From: Peter Davey [REDACTED]
Sent: 29 November 2018 11:14
To: Zac Denton
Subject: Planning Application - Sunny Bank, Dairy Lane, Walberton

Proposed North Elevation (side)
1:100 @ A3

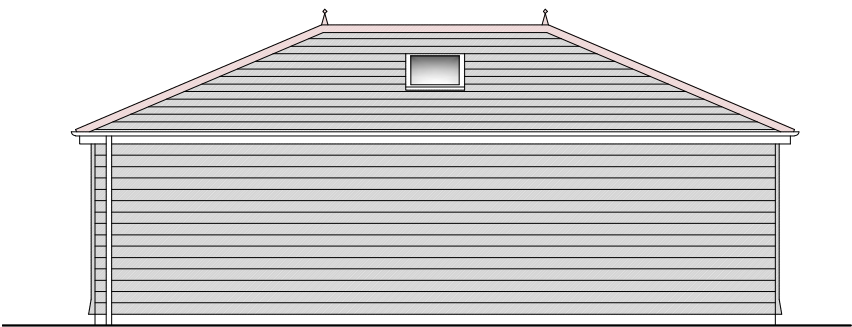
Further to our telephone conversation yesterday, I have spoken to the applicant who has agreed to include foliage screen along the northern (highway) edge of the proposed garage.

Do you wish us to define the details of the screening at this stage? Please find attached a sketch. I believe any screening will need to be at least 2.4m high to afford any meaningful level of screening.

The applicant and I discussed various options such as a laurel hedge or a climbing plant (clematis or rose) on a trellis or arbor, but any option would take time to establish.
